FIVE ESTUARIES OFFSHORE WIND FARM

10.59.1 APPLICANT'S COMMENTS ON NATURAL ENGLAND'S DEADLINE 6 SUBMISSIONS

Application Reference:	EN010115
Document Number:	10.59.1
Revision:	A
Pursuant to:	Deadline 7
Eco-Doc Number:	005711027-01
Date:	March 2025

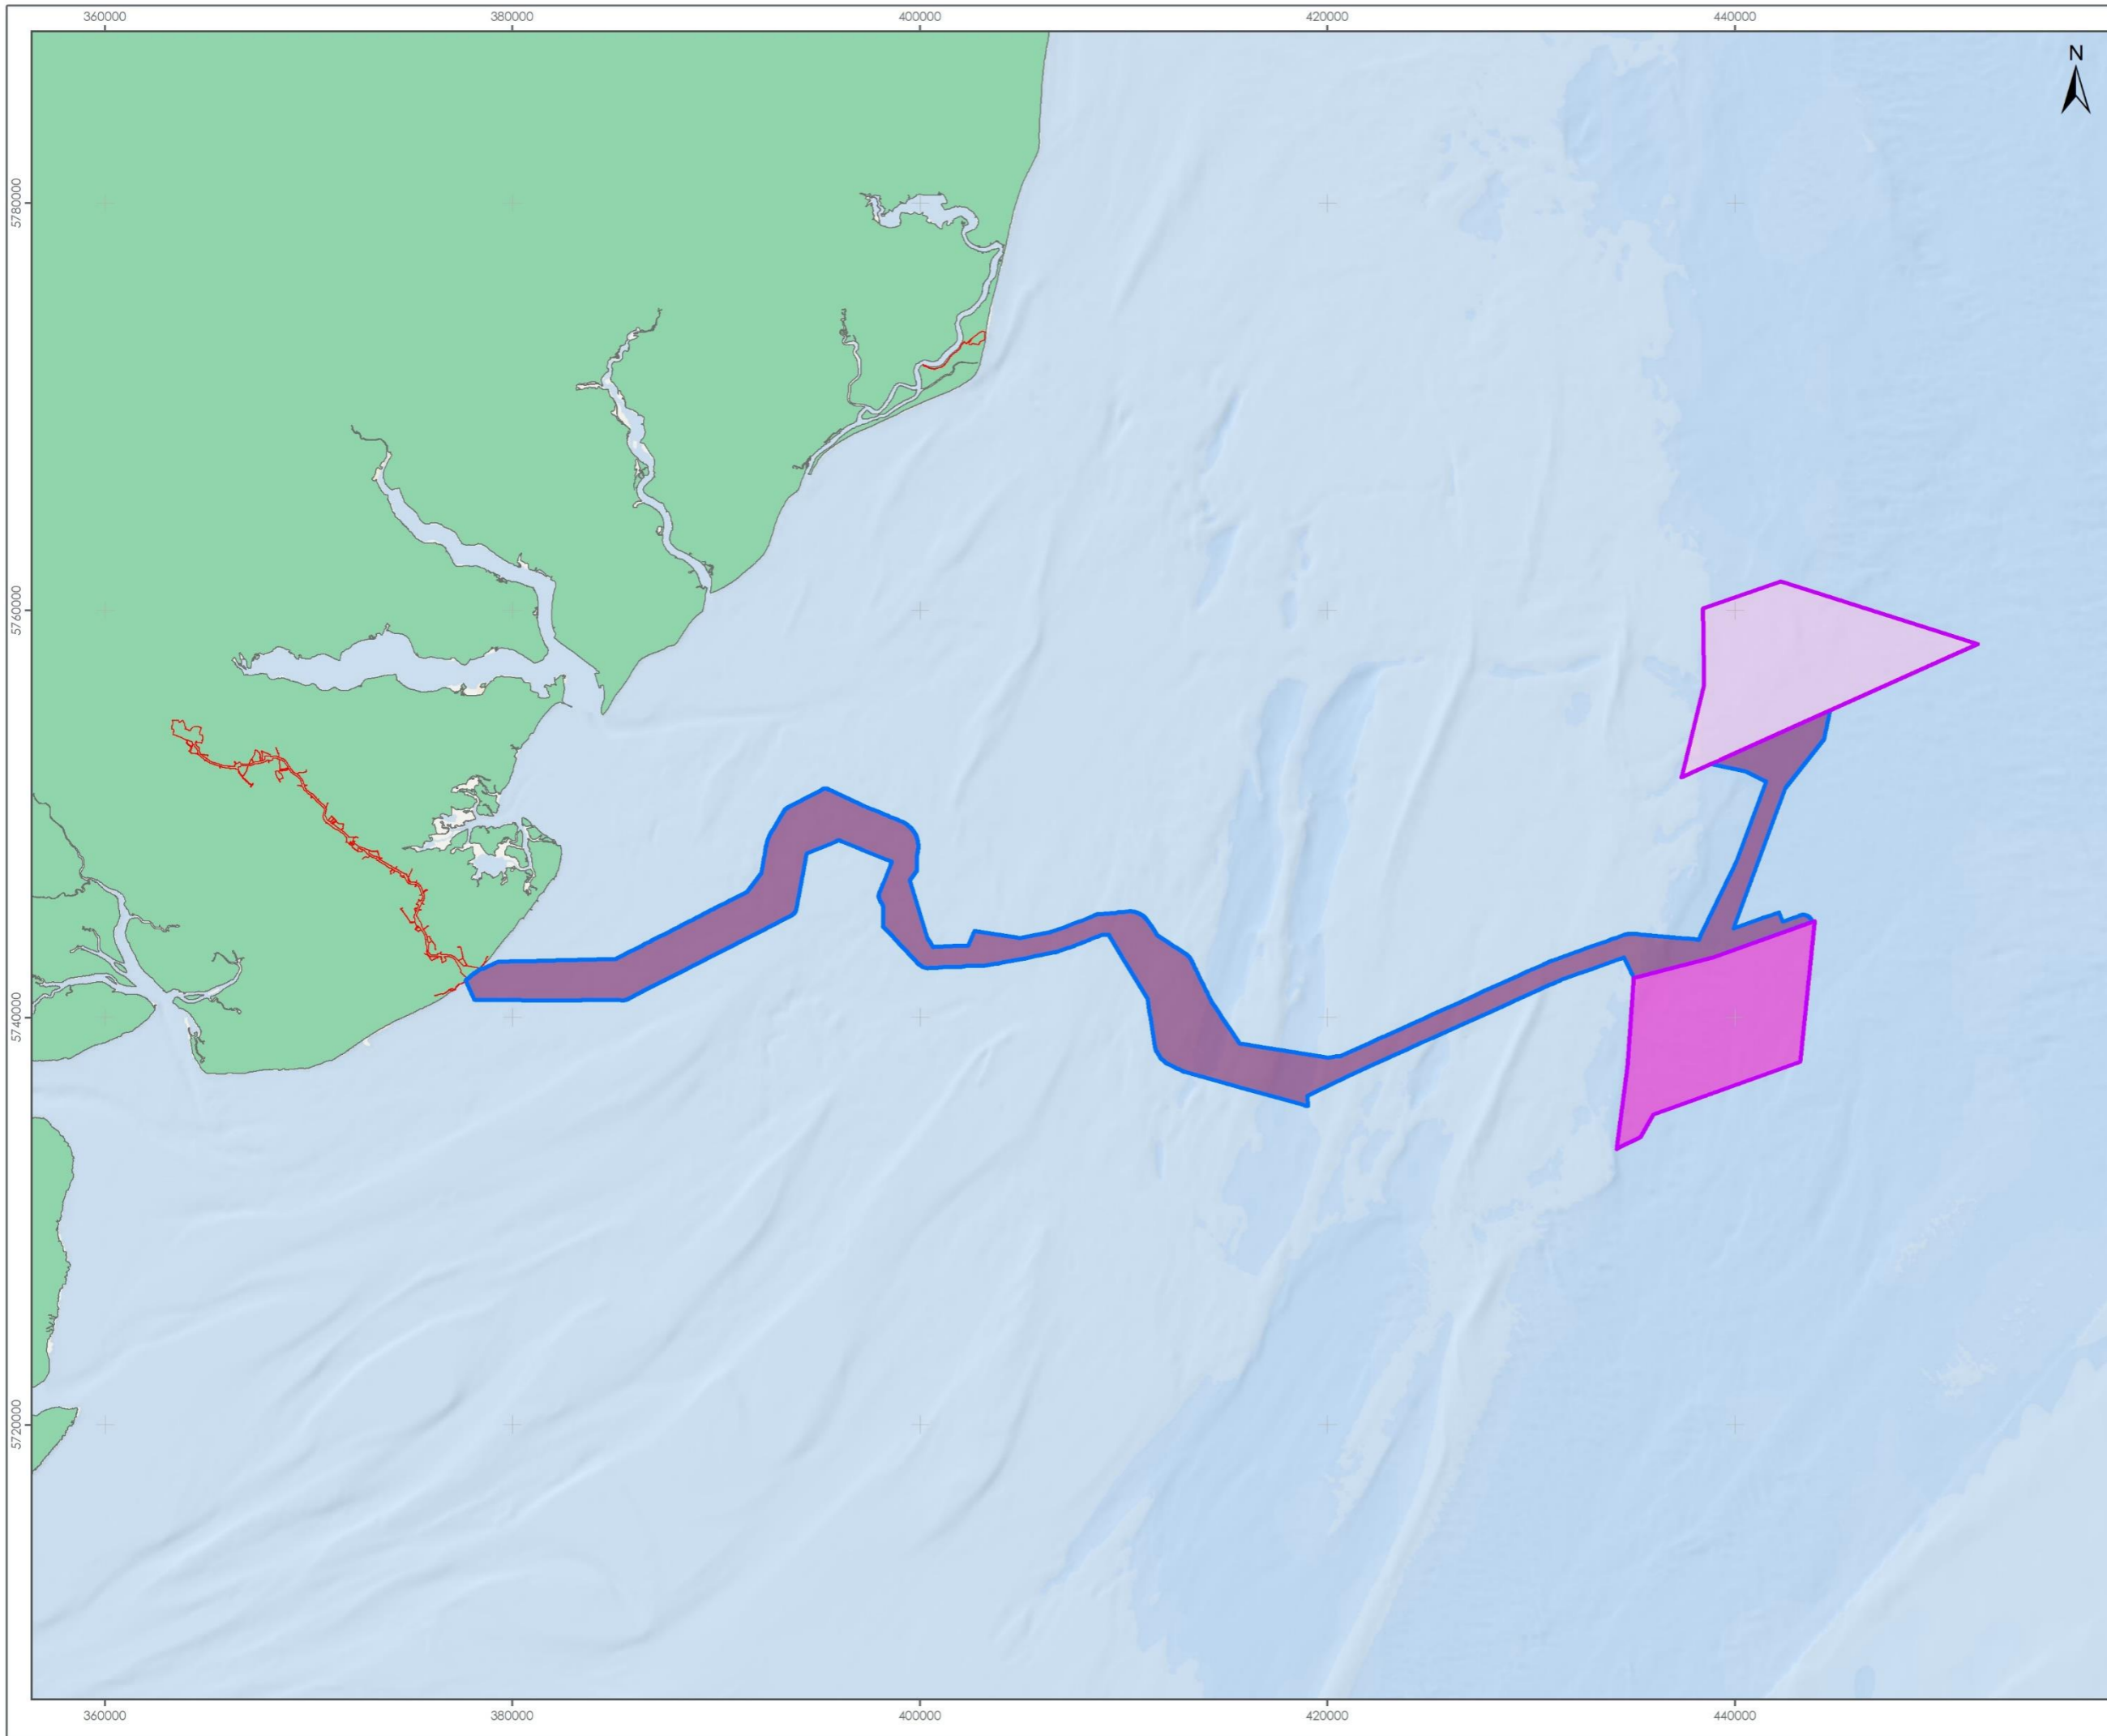
Ref	Natural England Key Concern	Natural England’s Advice to Resolve Issue	Applicant’s Response
9.8 Dredge Disposal Site Characterisation Report – Revision B (Tracked)			
1	Natural England suggests that there are in fact 3 disposal areas namely, Array (North and South), ECC outside SAC and ECC within SAC	Natural England suggests this, and other documents are updated to ensure that there are no ambiguities of what is proposed where	<p>The Applicant considers the current naming of disposal sites i.e. Disposal Site 1 (Array Areas) and Disposal Site 2 (Offshore ECC) to be sufficient and correct.</p> <p>As highlighted in responses below, 10.13 Outline Sediment Disposal Management Plan – Revisions C and 9.13 Margate and Long Sands SAC Benthic Mitigation Plan - Revision E have been updated with further commitments to minimise impact upon Margate and Long Sands SAC.</p>
2	The commitments for sediment disposal activities outlined within this document are not fully aligned with those listed in other documents such as the [REP4-041] 10.30 Outline Sediment Disposal Management Plan (which Natural England also advise should be updated – see other comments).	Natural England are aware that this document signposts to [REP4-041] 10.30 Outline Sediment Disposal Management Plan for specific commitments associated with sediment disposal. However, to ensure consistency and remove any ambiguity, all mitigation commitments listed within this document should be updated to align with those within [REP4-041].	<p>The Applicant considers that the appropriate place to outline specific commitments is within 10.30 Outline Sediment Disposal Management Plan – Revision C, which has been updated at Deadline 7.</p> <p>Although both documents do concern sediment disposal, the characterisation report (also updated at Deadline 7) describes the process whereby a proposed marine disposal site for spoil material and drill arisings generated by construction activities is described in terms of the existing environment. The Disposal Management Plan however, deals with the practical management for disposal of sediments and specifically details what measures will be undertaken in relation to constrained seabed areas, such as shipping routes or Margate and Long Sands SAC.</p>
